May 13, 2022

Re: PA22-015 - Colvin PRD – Technical Review 1

After preliminary review of the above referenced proposal, the Planning Division has the following comments:

PRELIMINARY ROAD, GRADING & UTILITY PLAN
COLVIN PRD

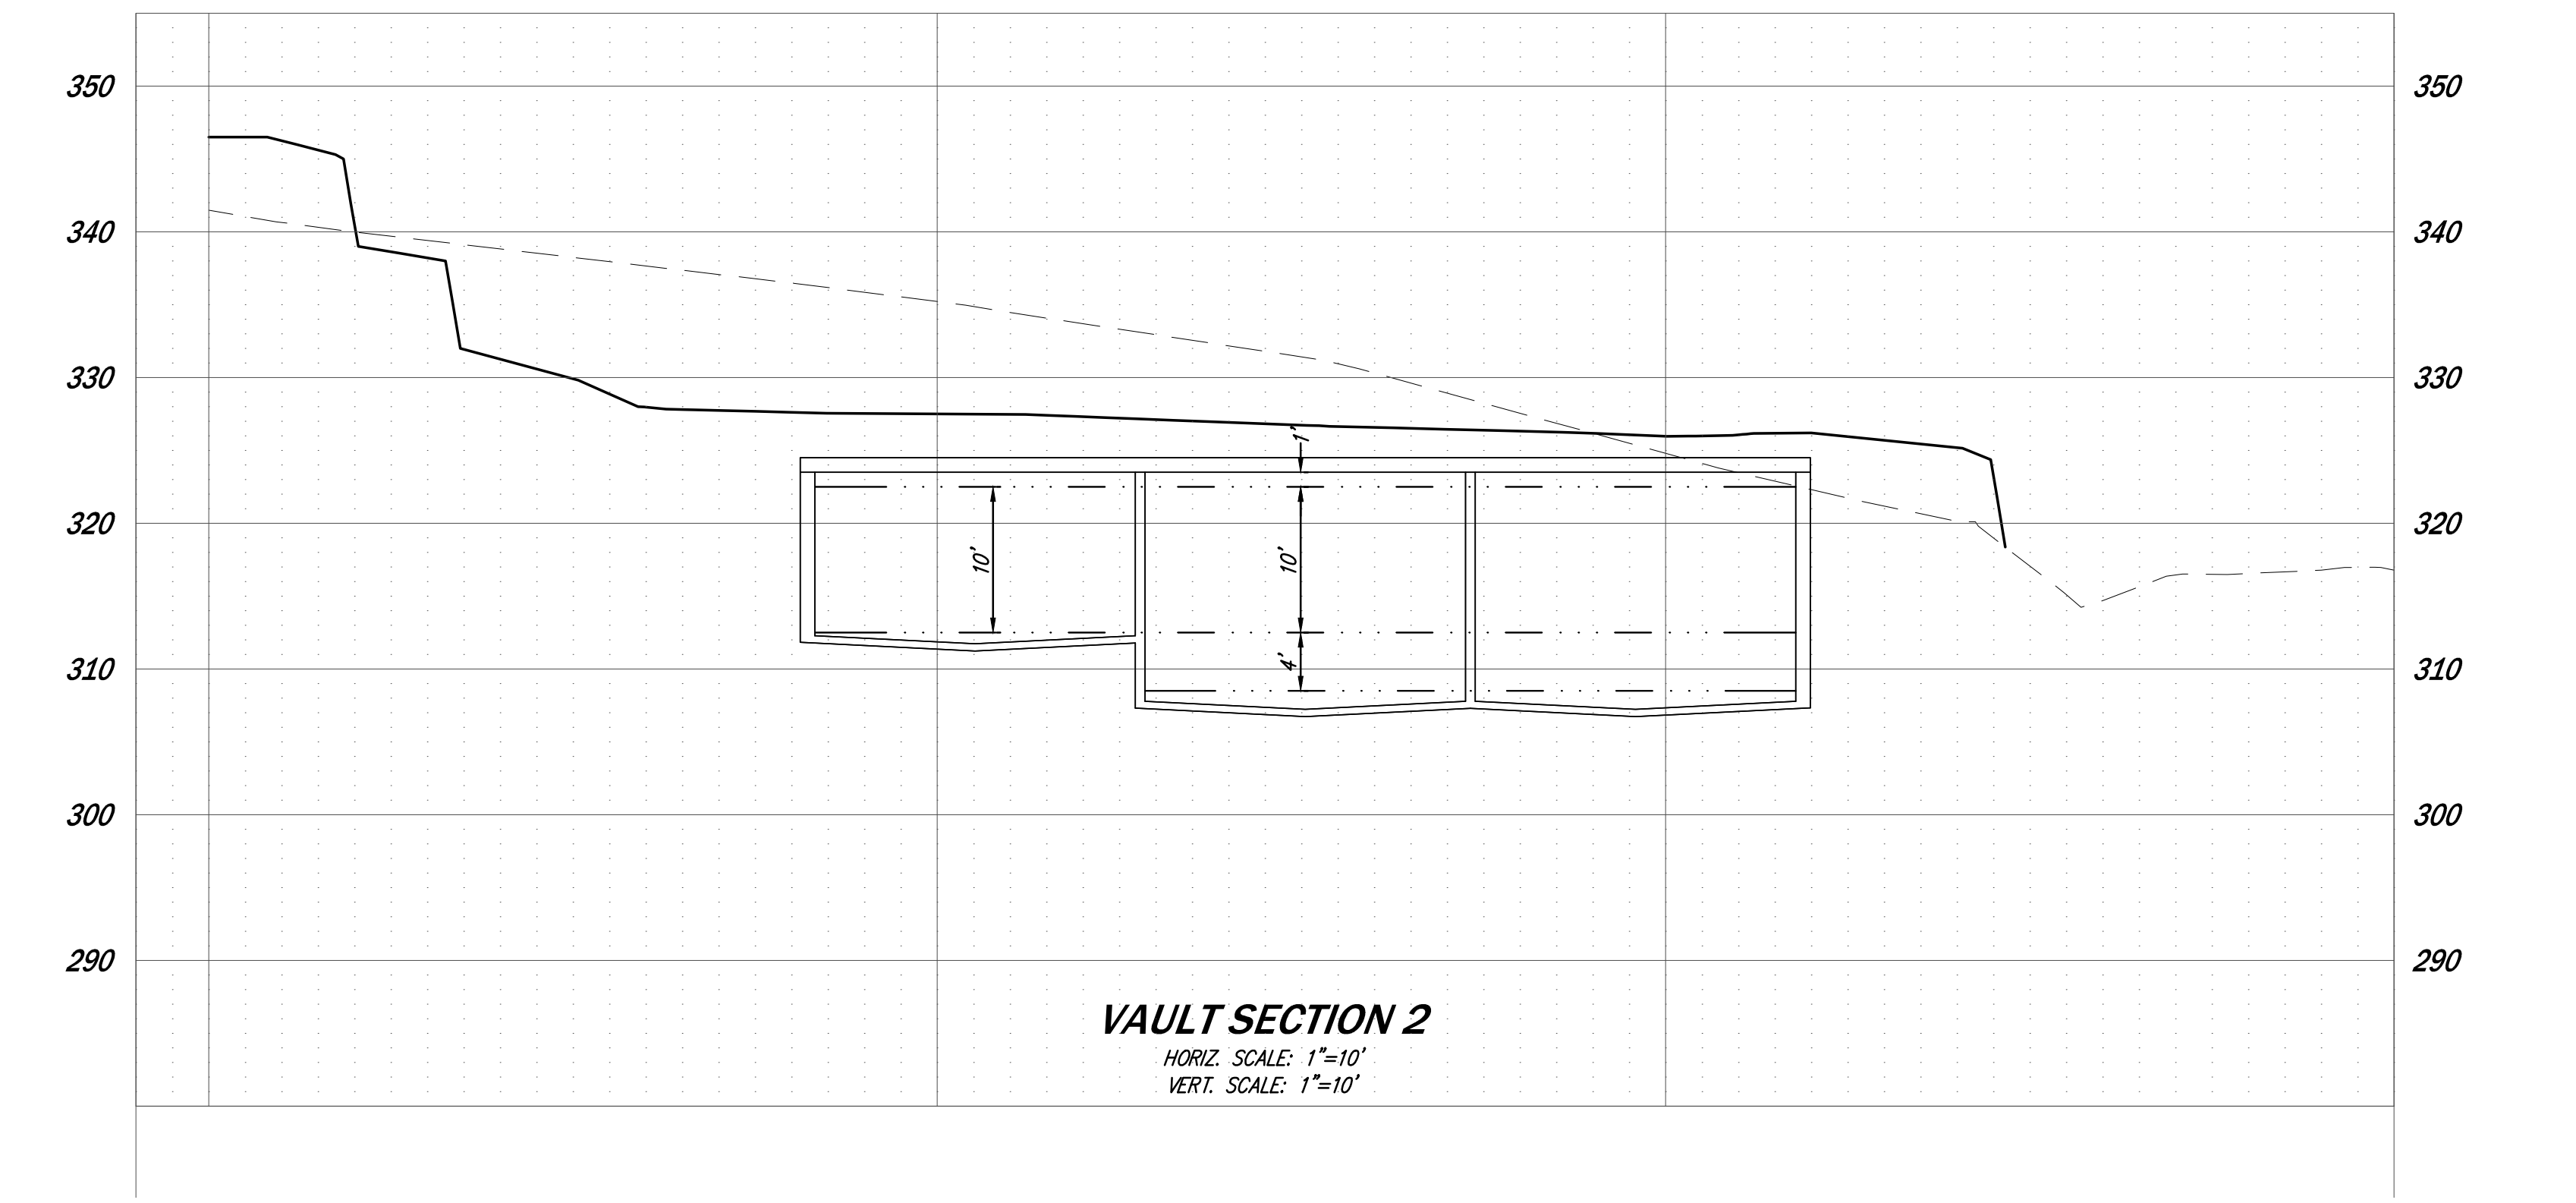
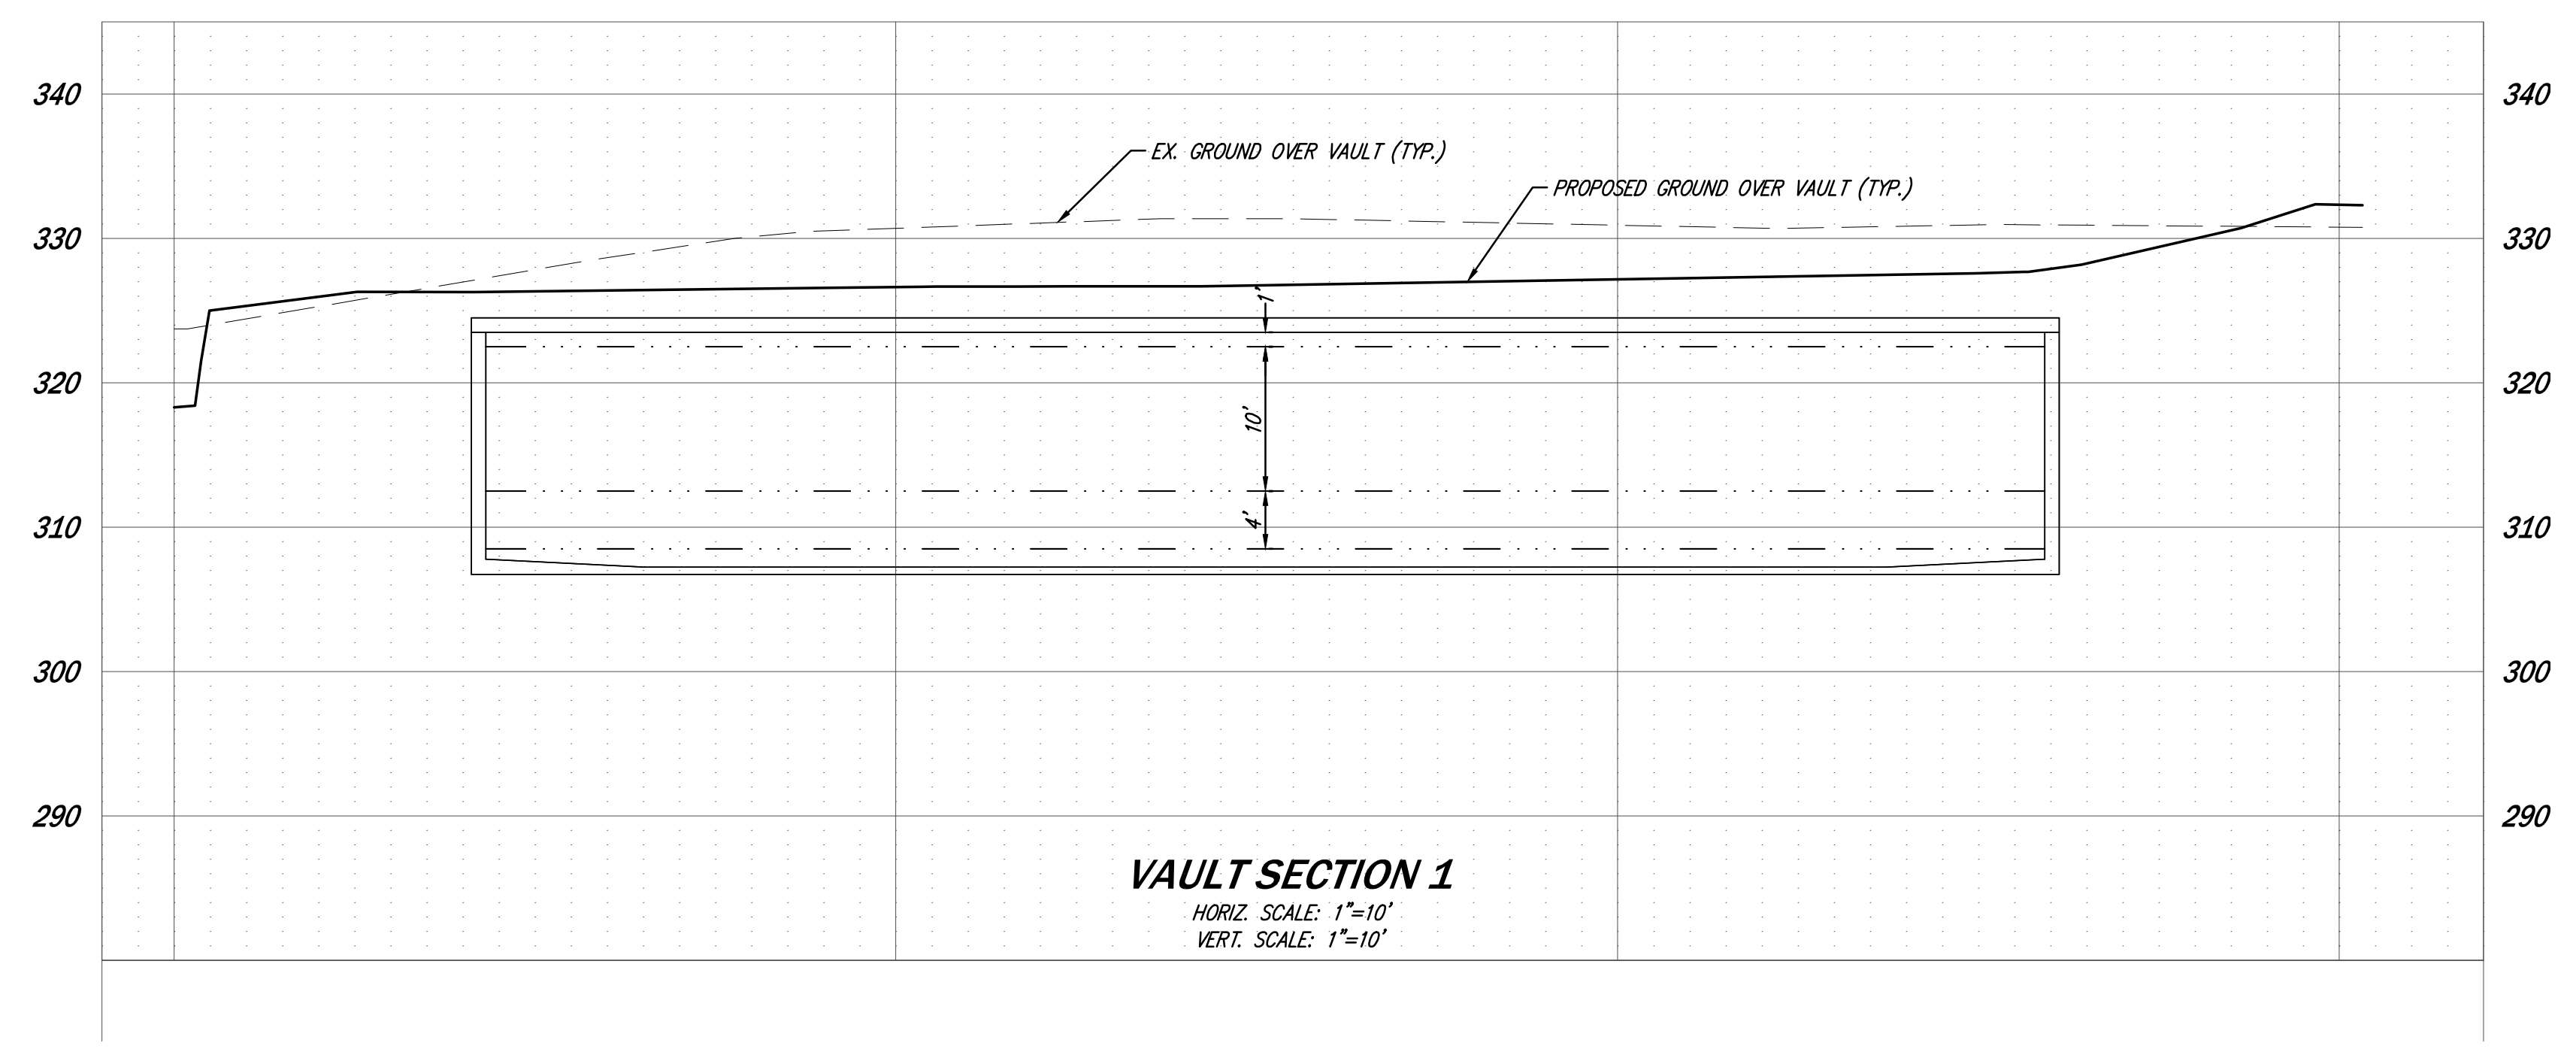
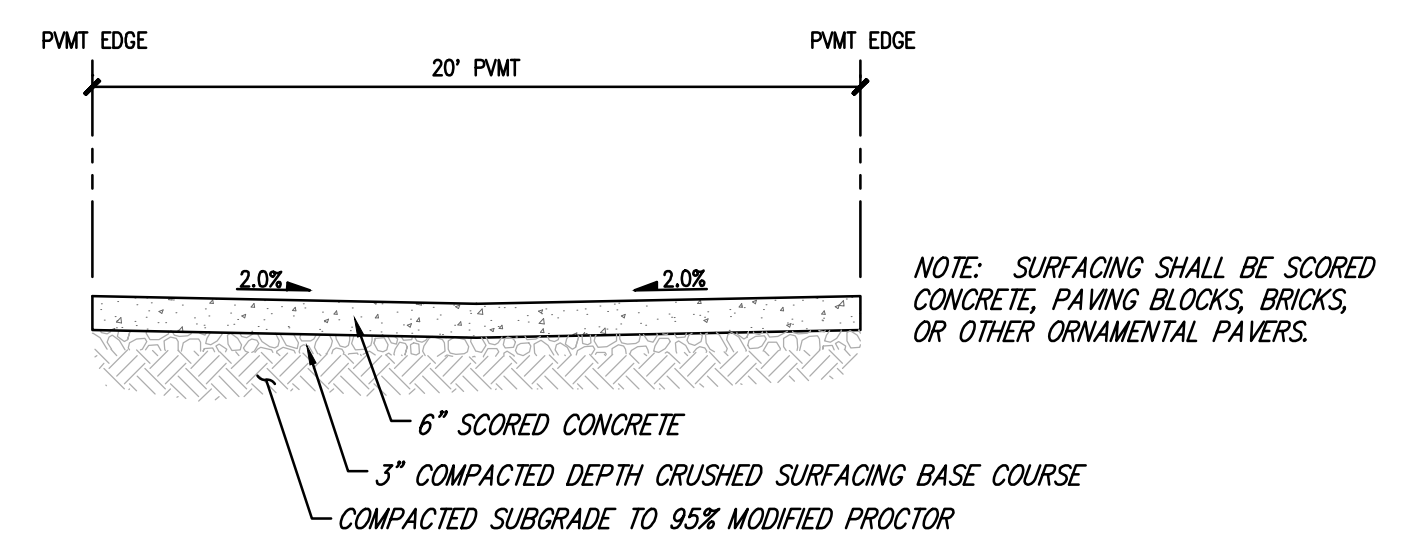
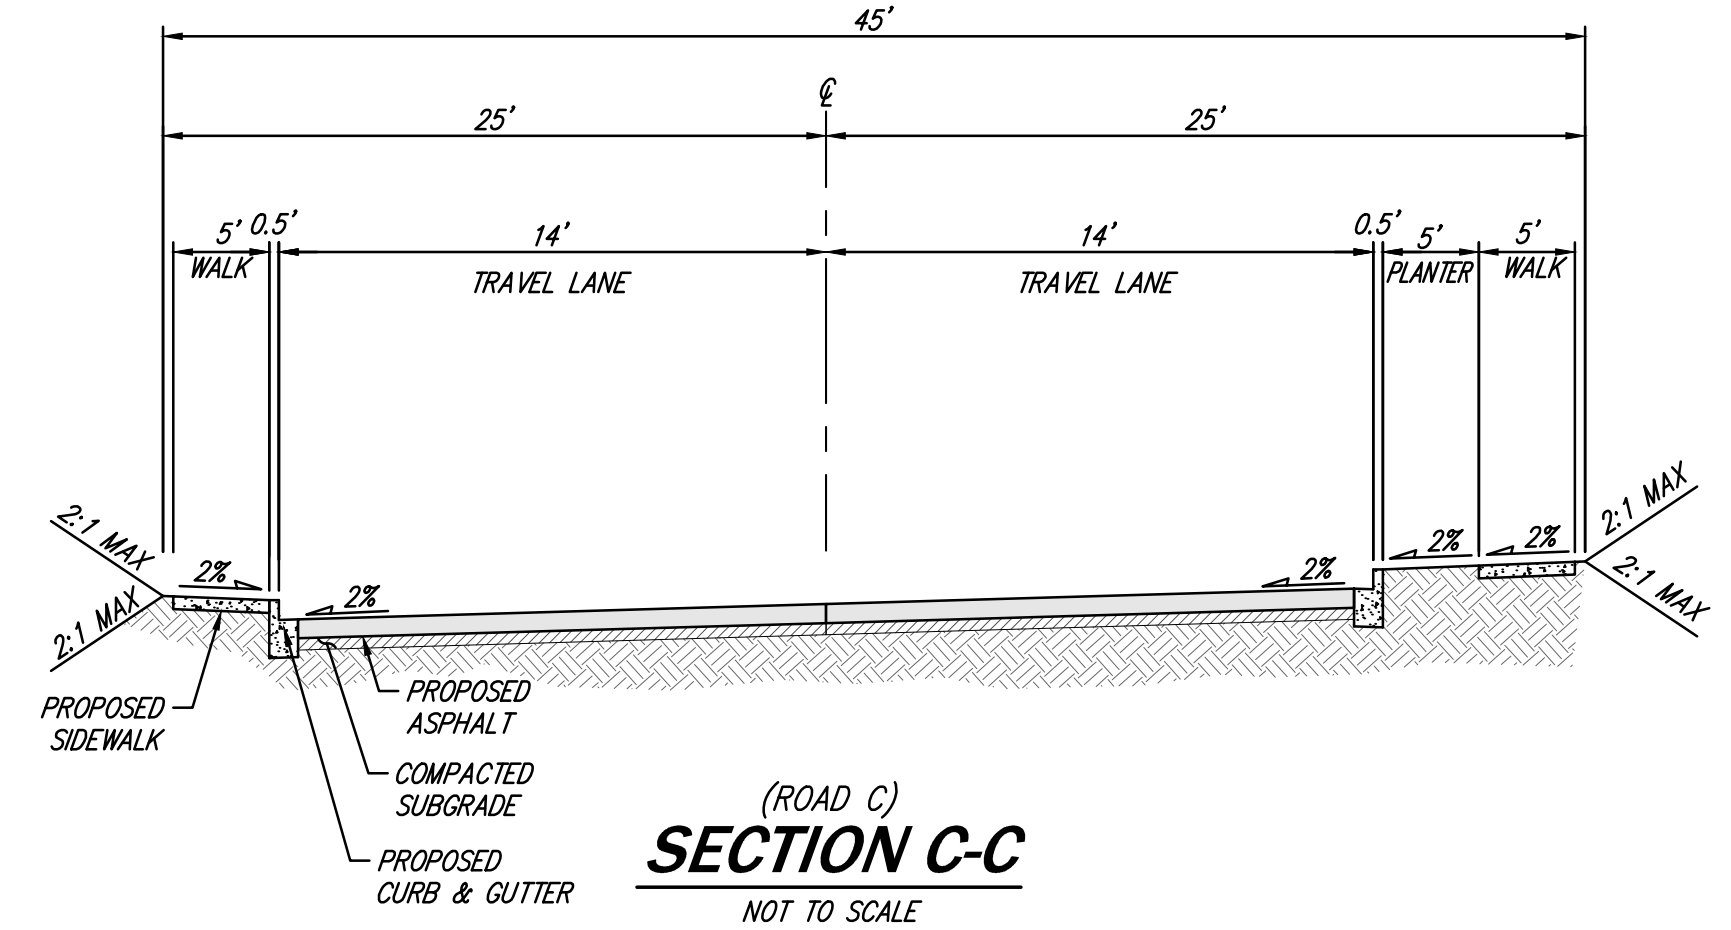
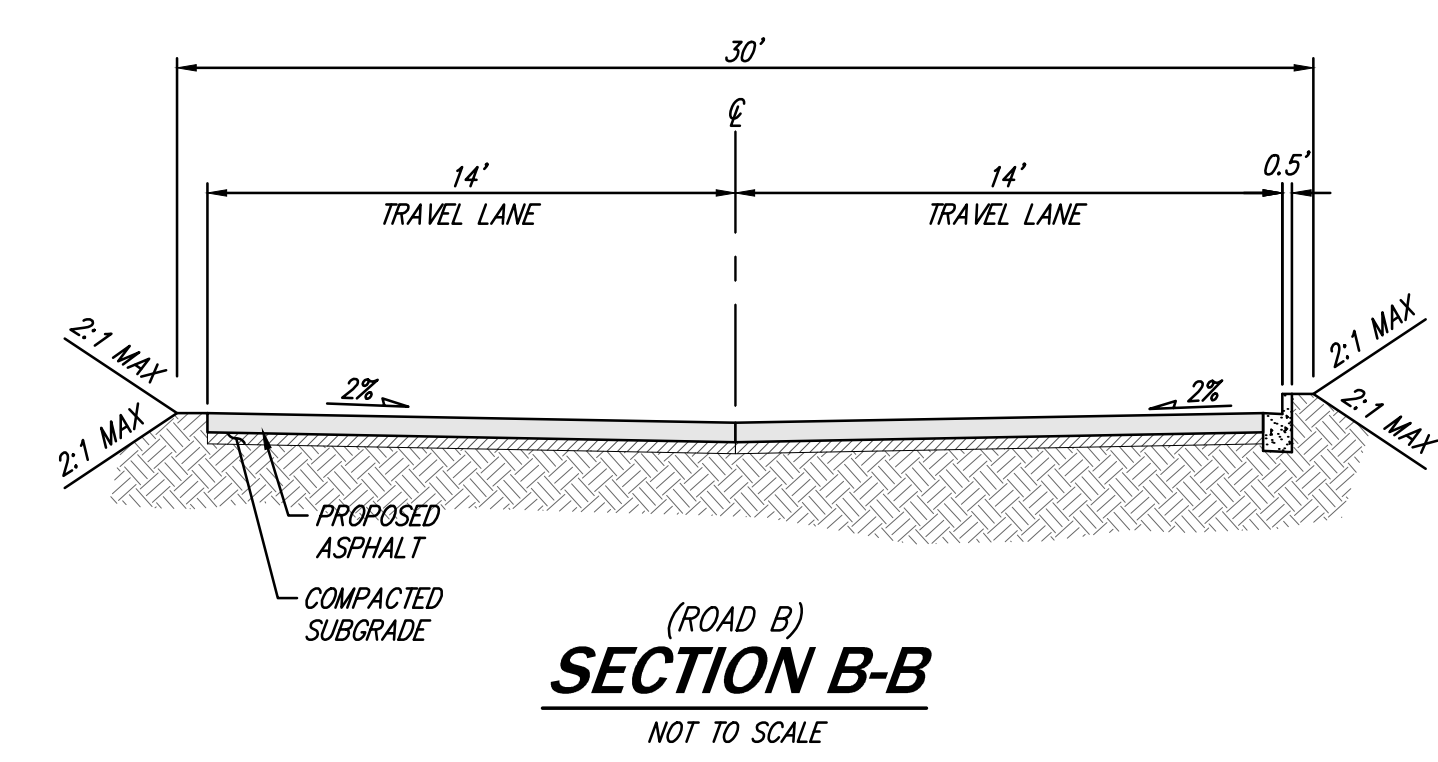
3. Based on review of **Sheet C4.01**, there appears to be multiple retaining walls exceeding the allowable 4 ft. threshold, which requires wall terracing. Please clarify how compliance with MMC 22D.050.030(4) is to be satisfied for the proposed retaining walls exceeding 4 ft. in height.

3.1. Please revise to add the top and the base elevations for all retaining walls as well as off-site topography to determine any impacts to adjacent properties due the wall massing.
